Recommendation Report for Planning Permission

REF NO: CM/8/21/PL

LOCATION: Climping College The Mill
The Mill Lodge
Climping Street
Climping

PROPOSAL: Construction of site perimeter bunding & associated planting to protect against flooding, associated excavation of a pond (retrospective) & construction of flood defence gates (resubmission following CM/25/20/PL). This site is in CIL Zone 5 (Zero Rated) as other development & may affect the setting of a listed building.

corten flood wall and gate
CM_flood wall + gate
Scale: 1:100 + 1:50 @ A2
Date:18.01.2021

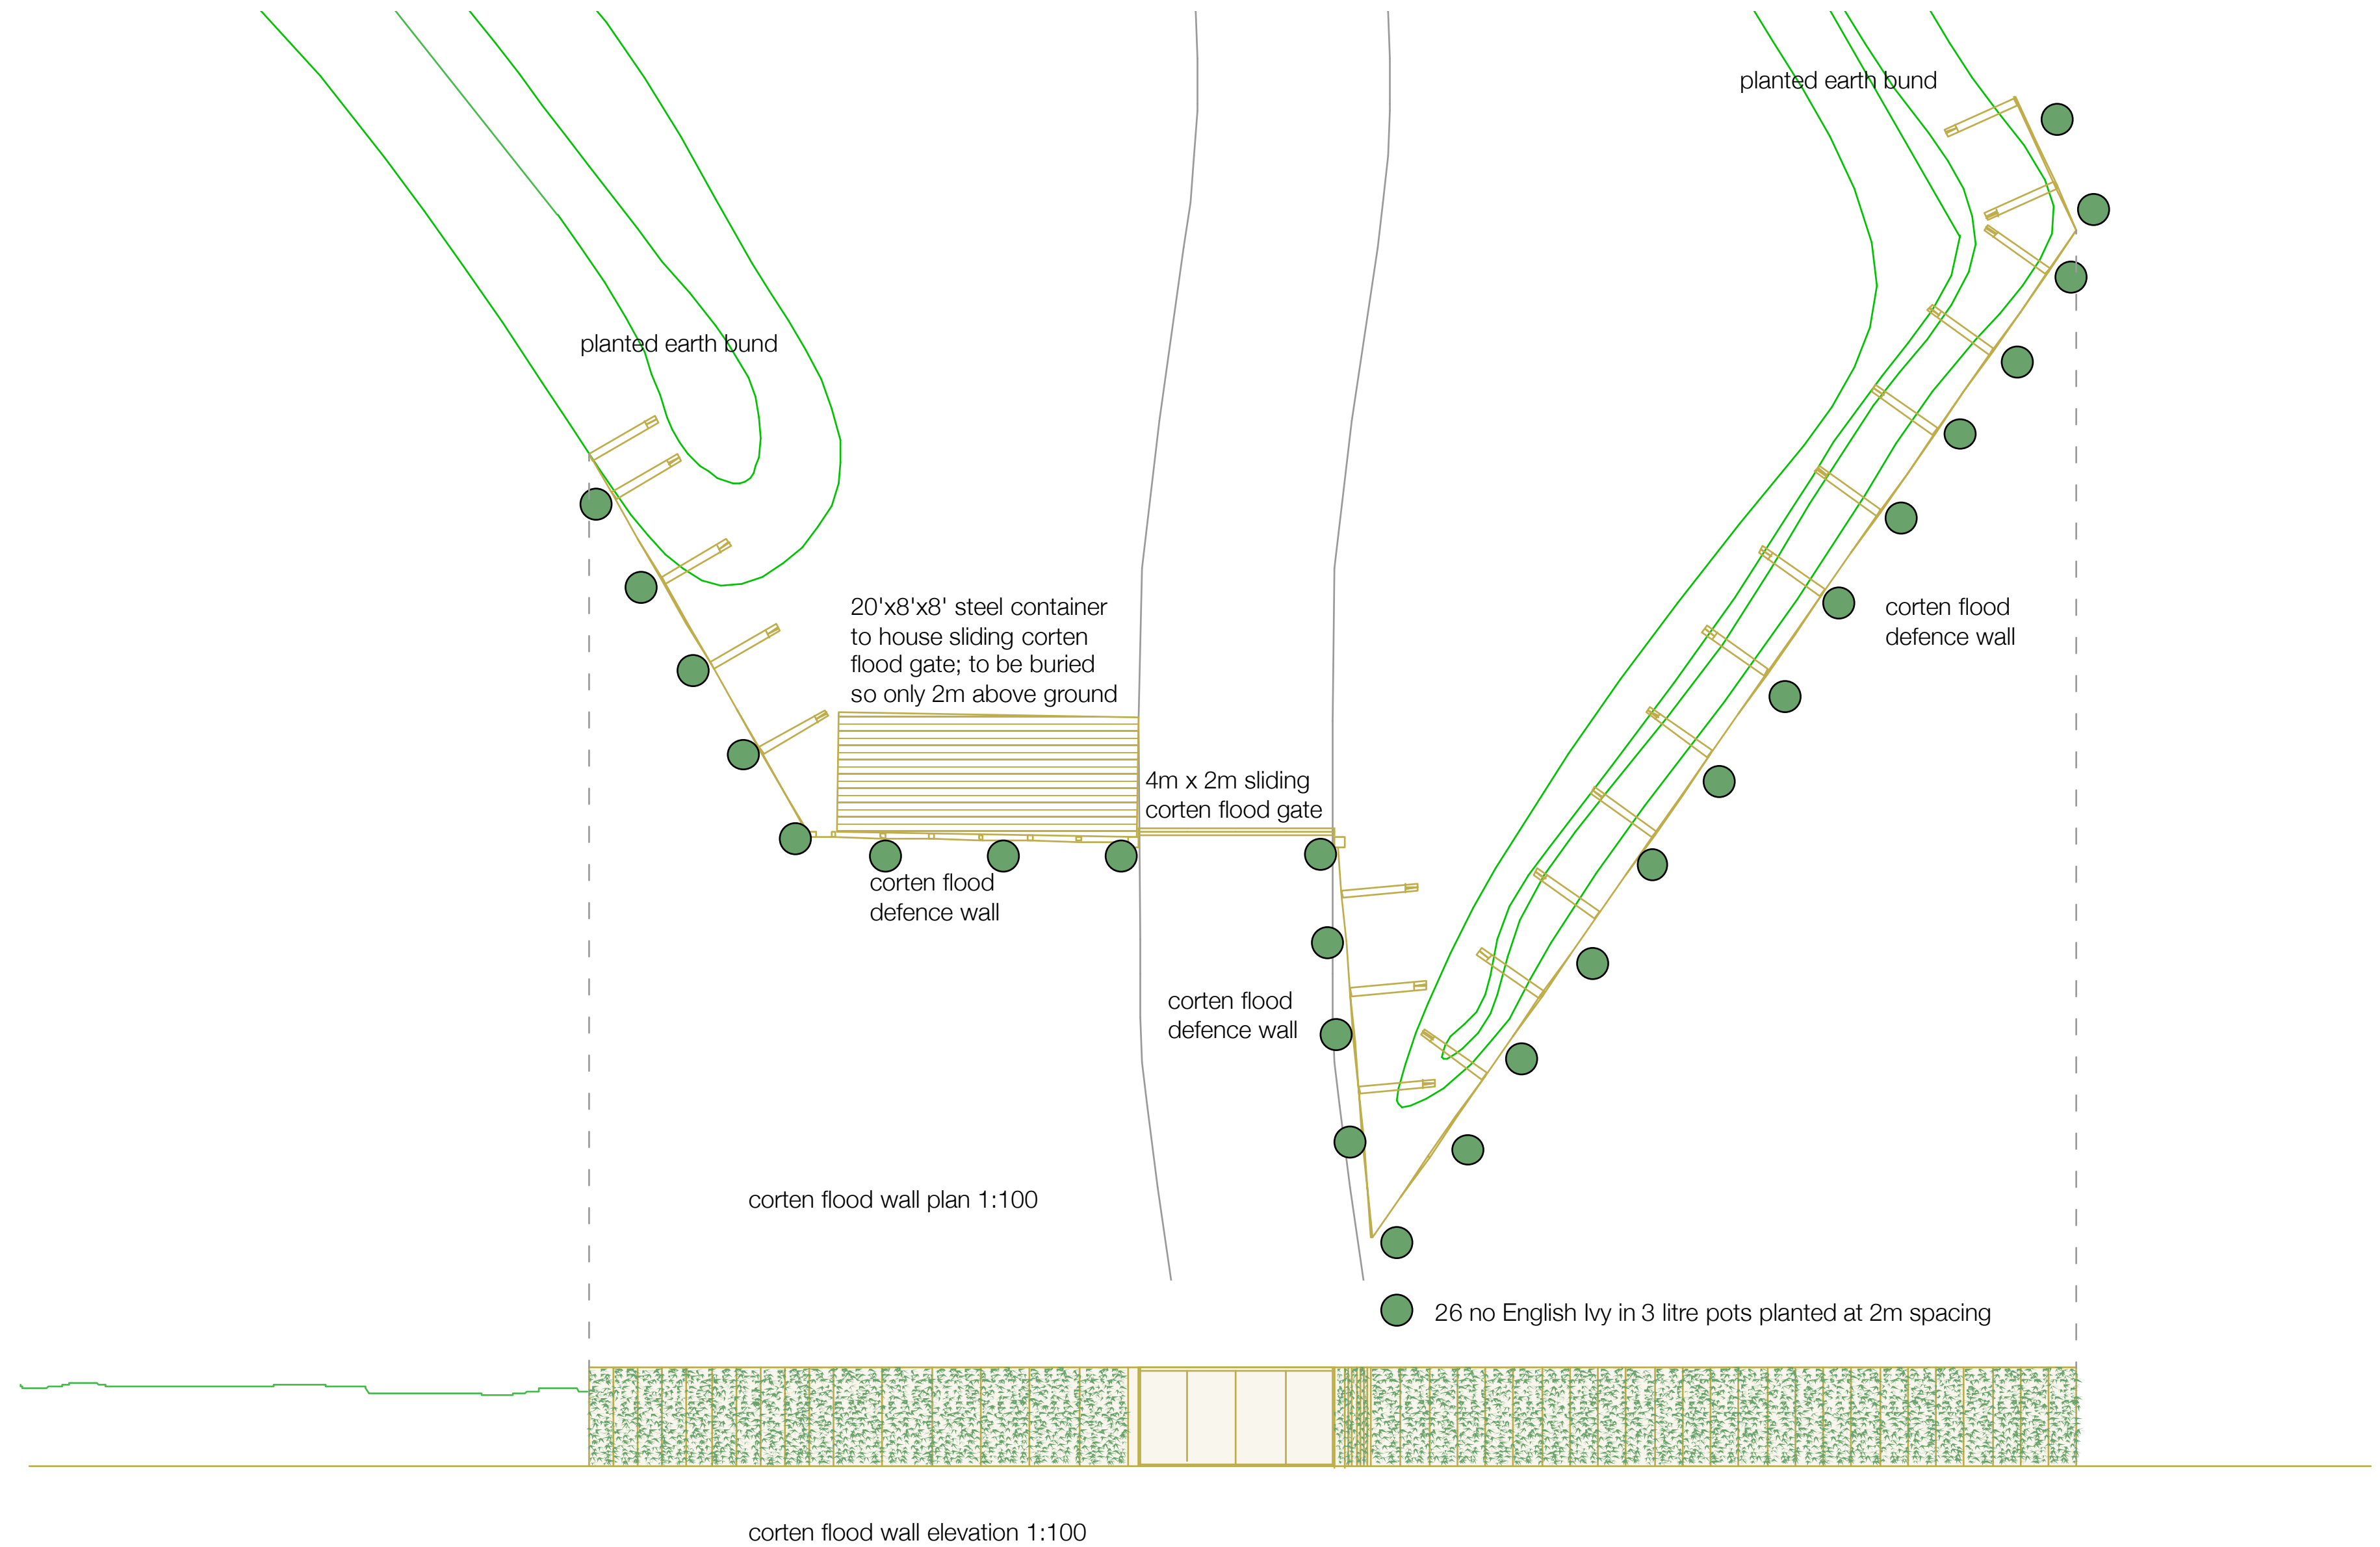
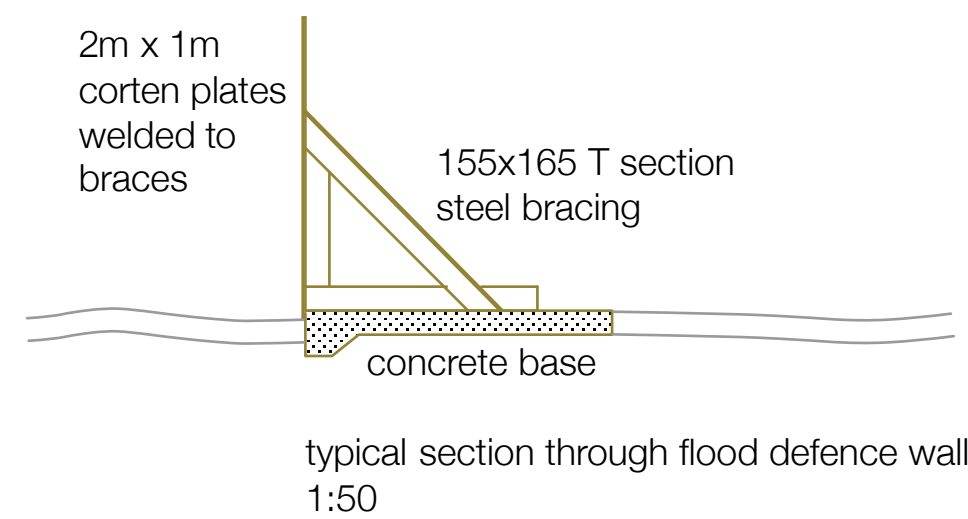
CM/8/21/PL uses the corten steel flat plate wall to join the western bund to the gate (and in doing so screens the container housing the gate). The corten steel wall continues east of the gate to provide an eastern flank wall approx. 26m long which seems to duplicate the purpose of the earth bunding, although the bunding is not shown on the cross-section provided. The vertical face of the corten steel wall is provided with Ivy planting. Would 3 litre pots would be sufficient for each plant to thrive and they do not seem to have any supporting mechanism to enable them to fully screen the corten steel?

The supports to the corten wall in both applications is shown as a concrete base with horizontal, vertical and raking steels. There is no sign of lateral support (ie horizontal bracing) and so the Applicant should show that the structural integrity under load is sufficient. It is not shown whether the concrete support is continuous or just at the support locations - if it is not continuous then it is unlikely that the flood risk purpose will be provided unless the steel is buried into the ground by a reasonable amount. The steel structure would be unlikely to resist direct wave action - however, given the predictions for the evolution of the coastline (below) this is unlikely to occur, at least in the medium term.

The degree to which the containers are landscaped varies between the two applications. In CM/8/21/PL there is nothing above the top level of the corten steel wall. Indeed, the bunding to the west is approximately 1.5m above surrounding ground whereas the top of the wall and the container for the gate is shown as 2m above ground.

The containers are not noted as being filled and would rely upon the embedment to resist lateral movement (sliding/overturning) - it is doubtful whether the flood depth at this location would be sufficient to cause movement of the embedded containers for the short to medium term.

Pond Planting

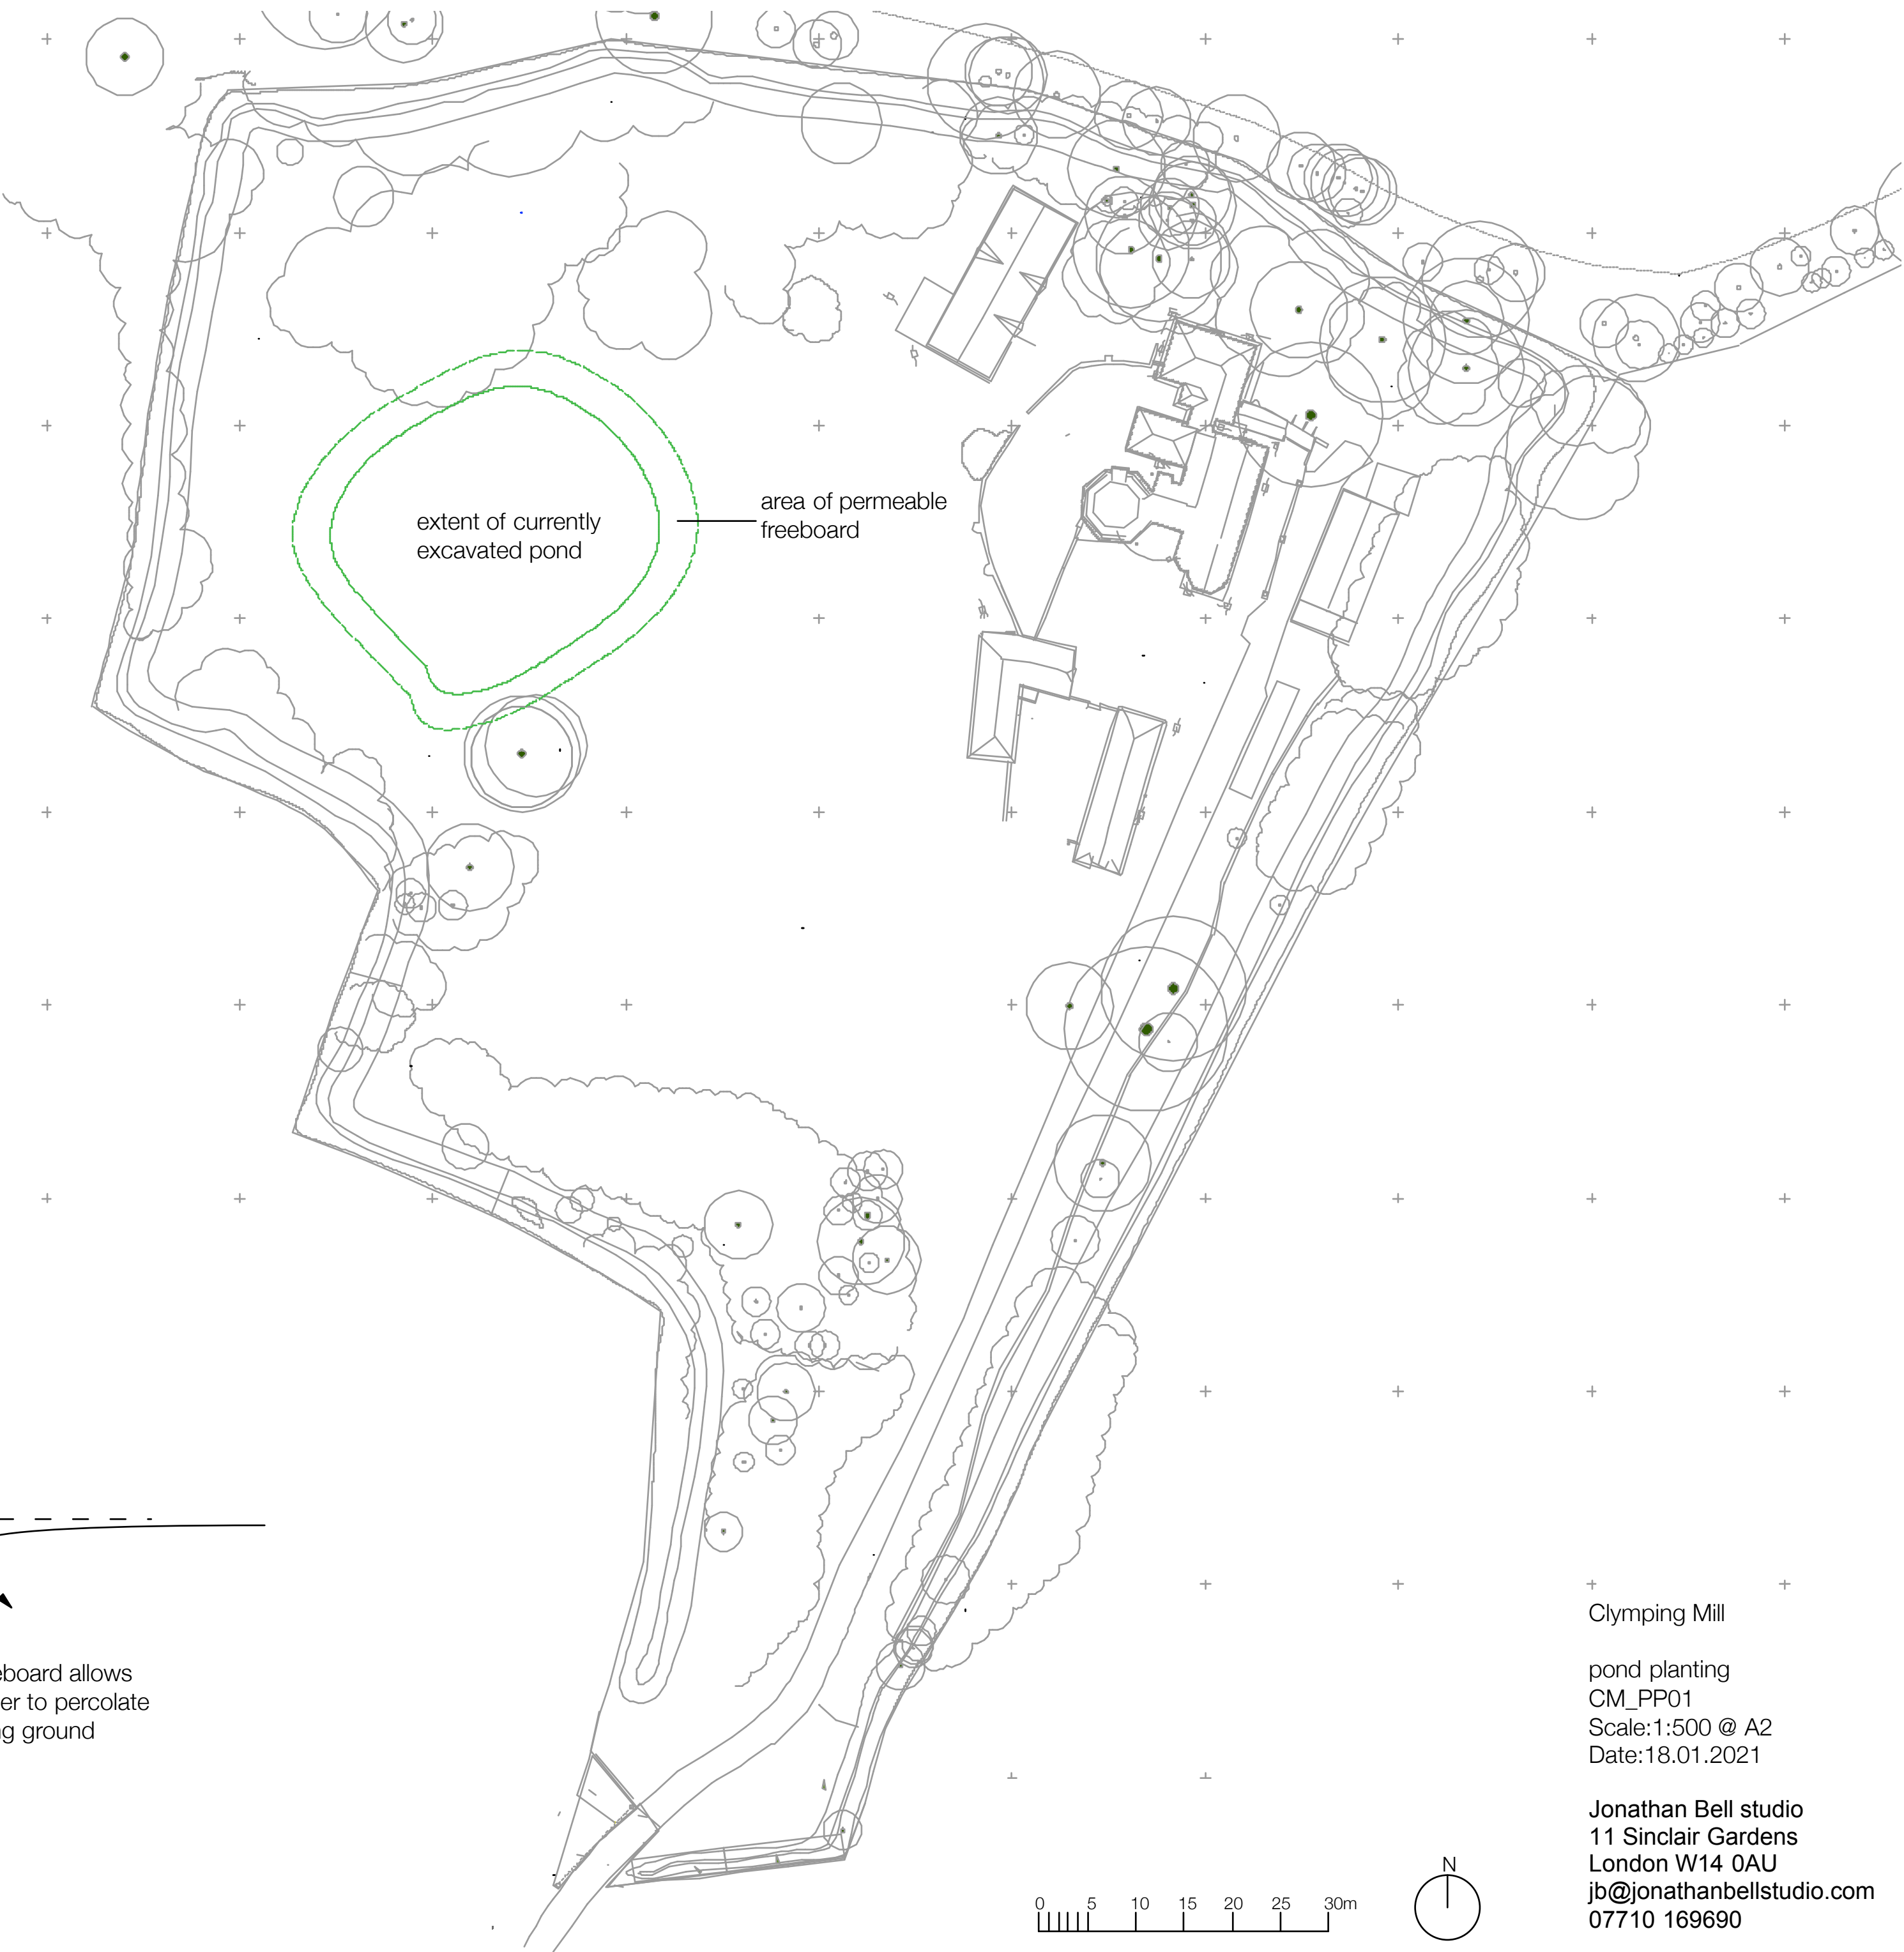
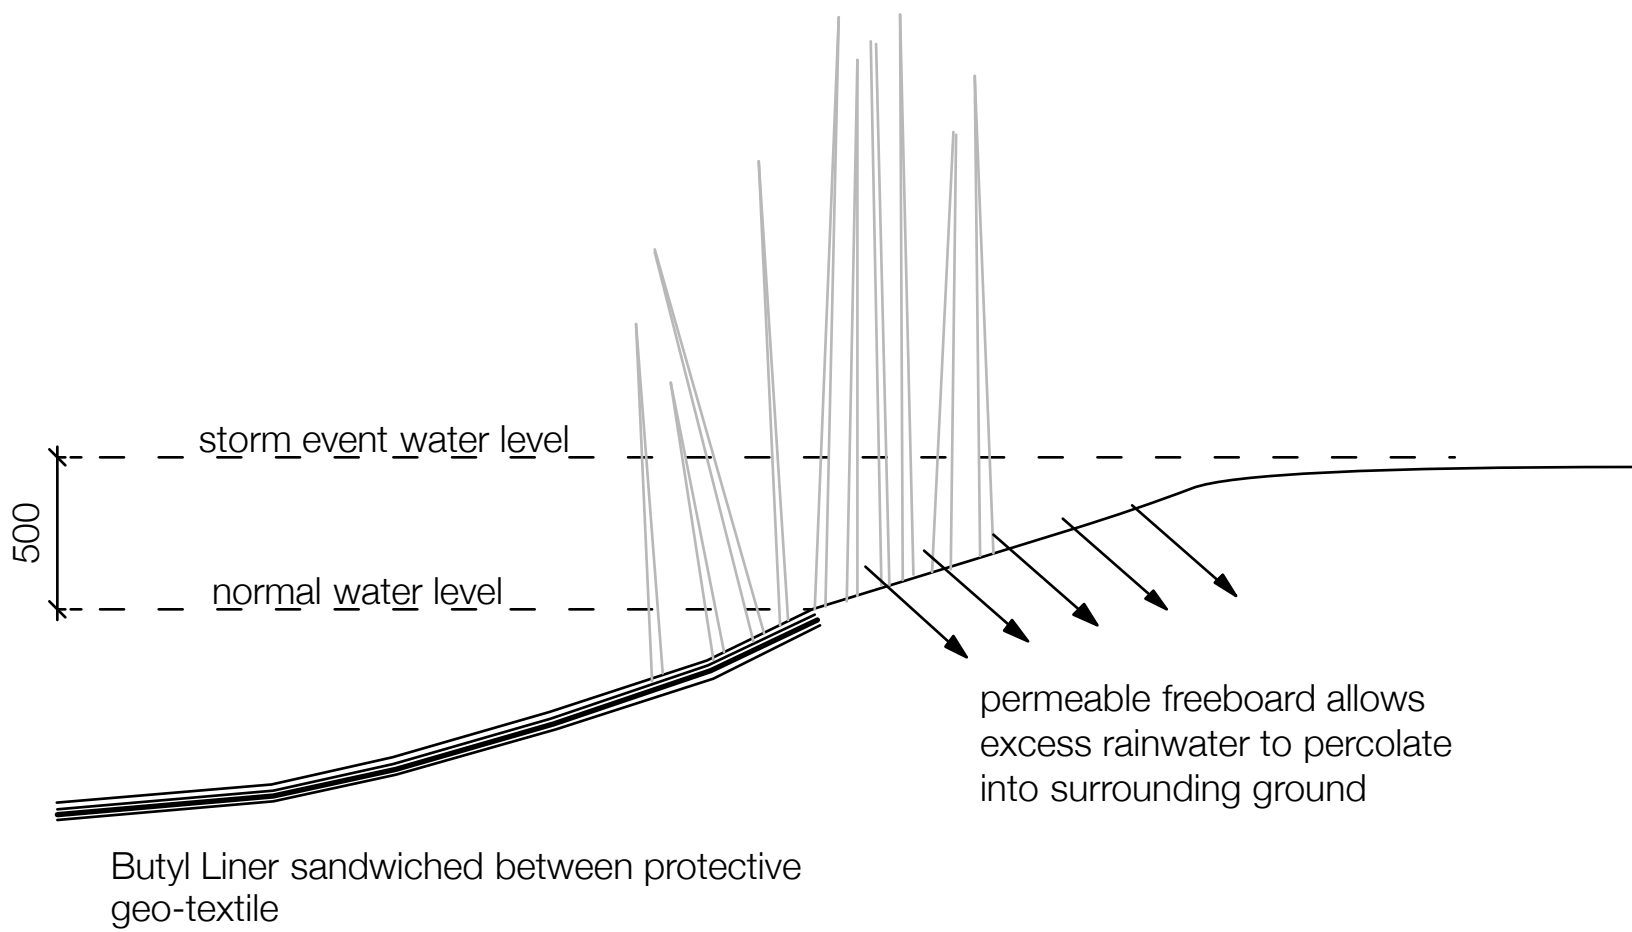
The proposals will provide ornamental and native improvements and potential biodiversity gain. Recommend that the actual quantities for the detailed species mixes be provided.
